Re: Drainage for Plat 7111300002

The purpose of this letter is to address the drainage requirement for the site plan for ABC Landscaping.

Site Plan

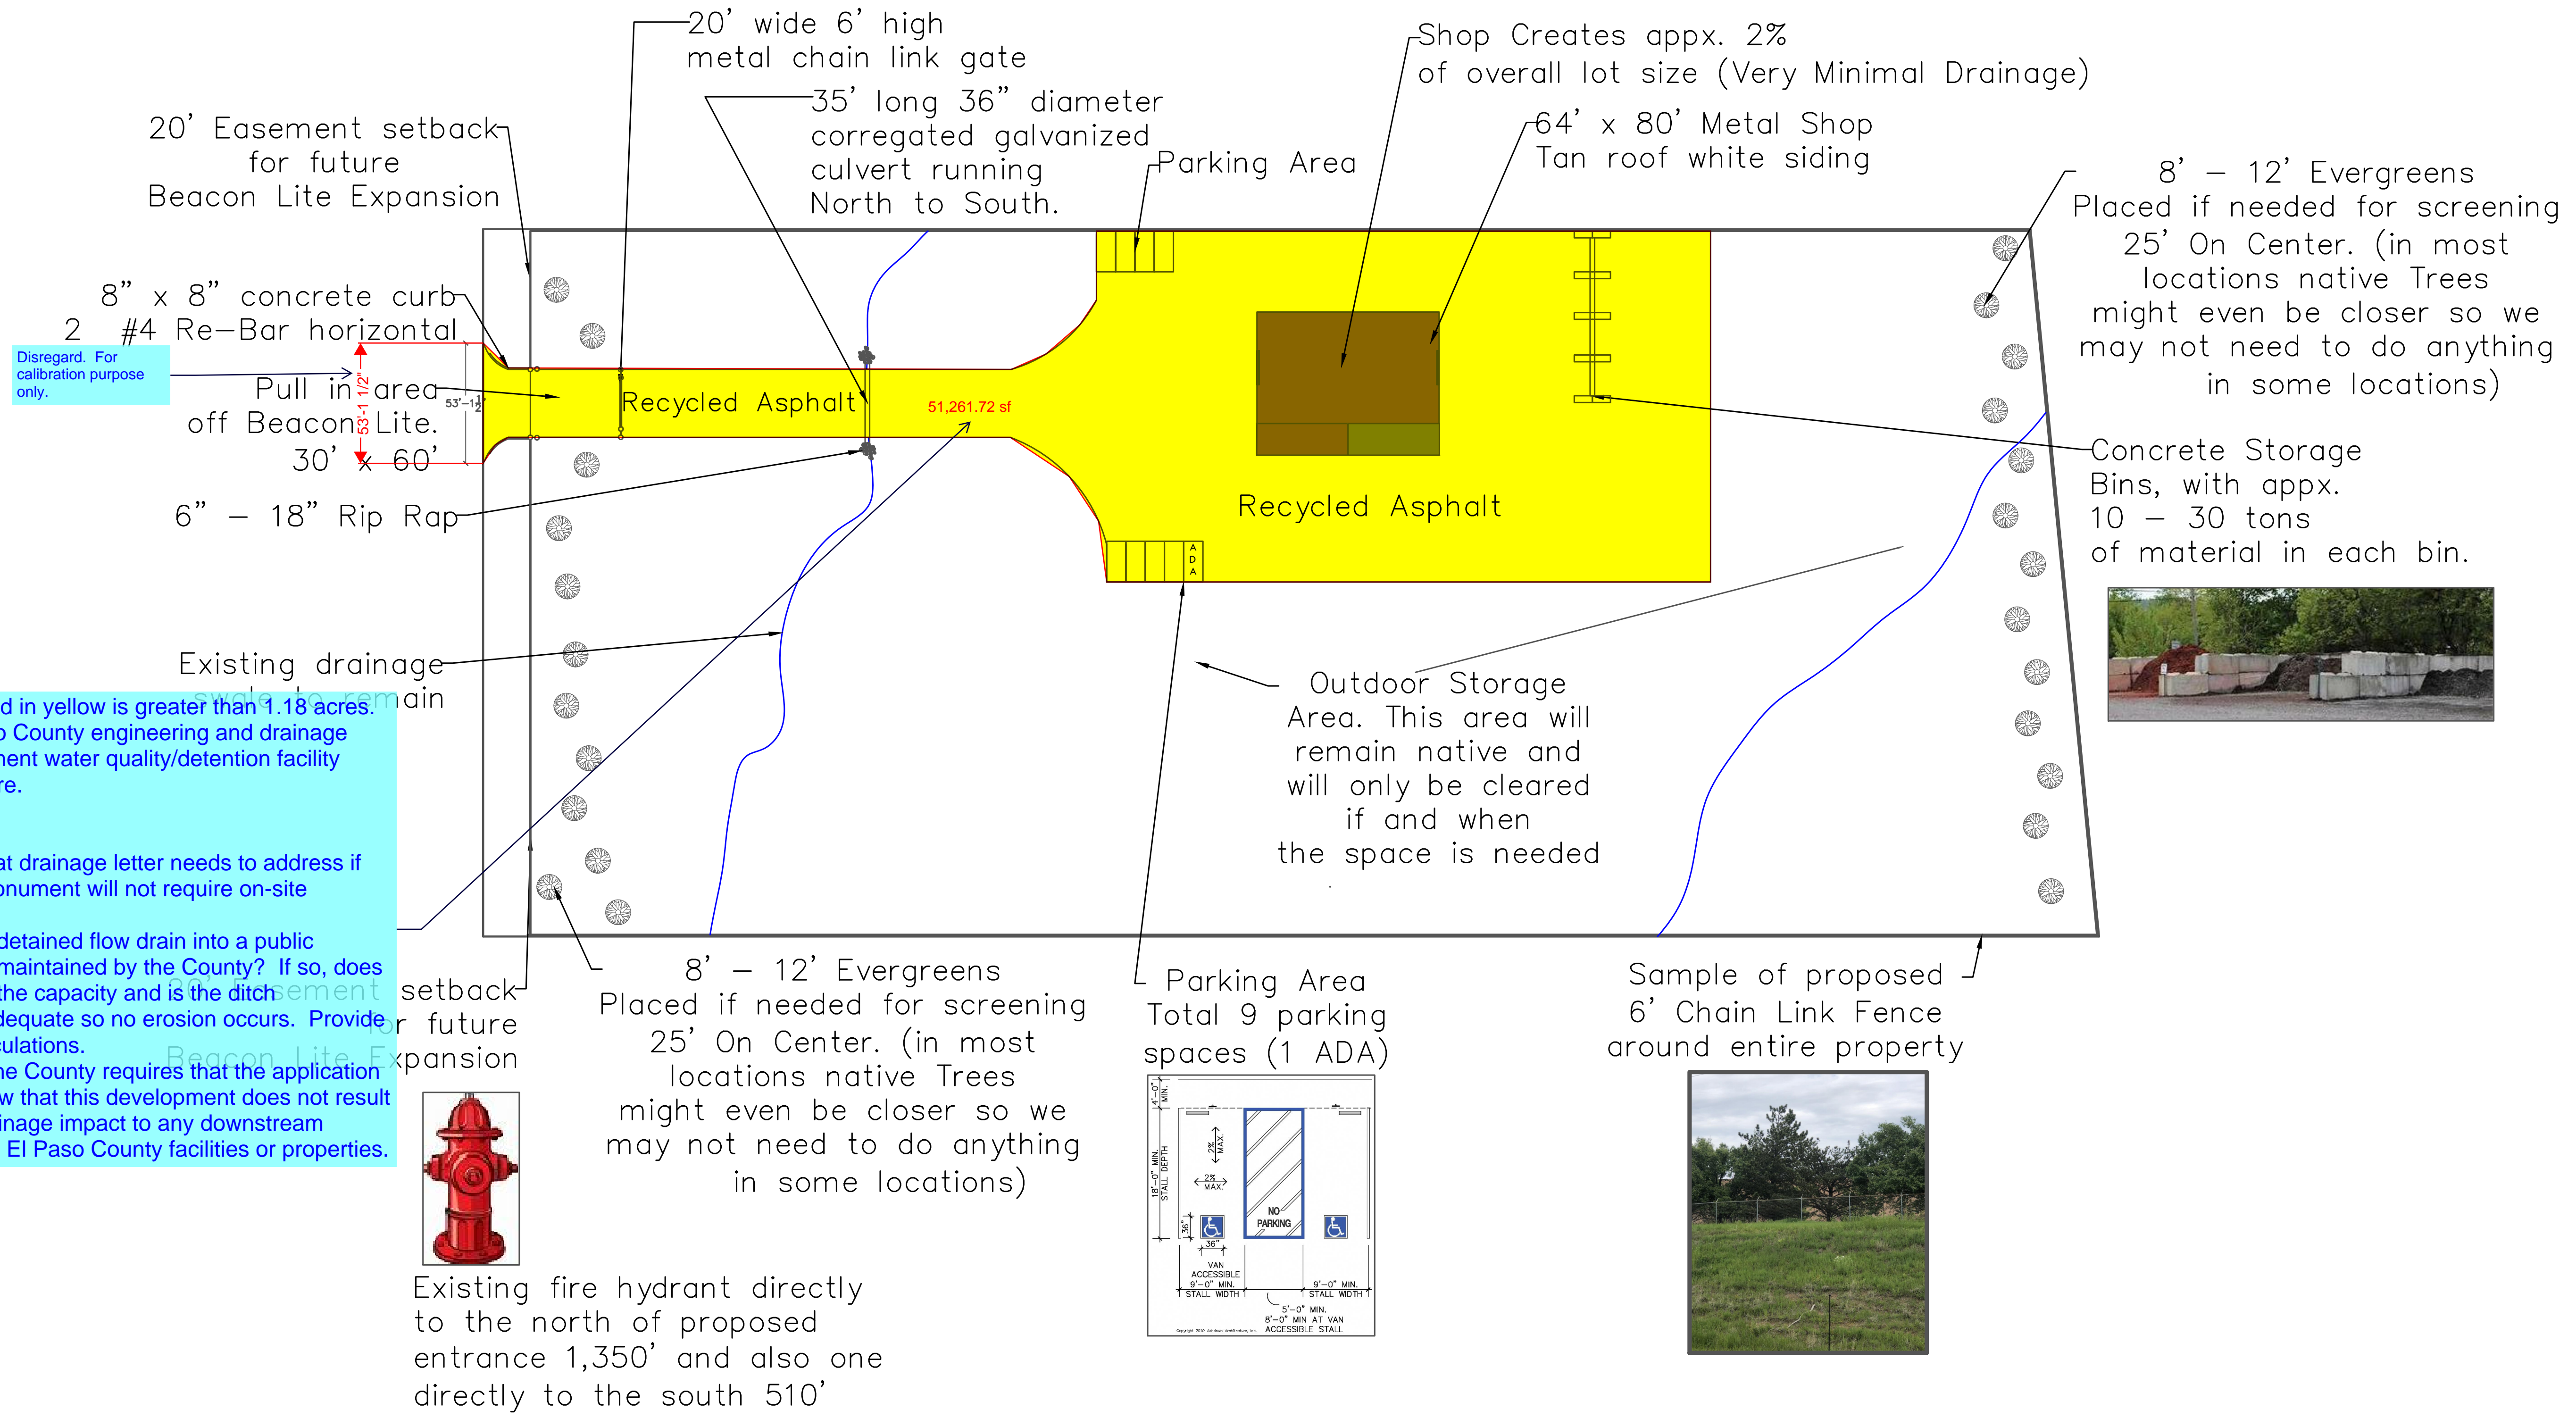
The existing drainage swale will remain adequate with the proposed 36" culvert under the access drive. Flared end sections with riprap on either end is appropriate.
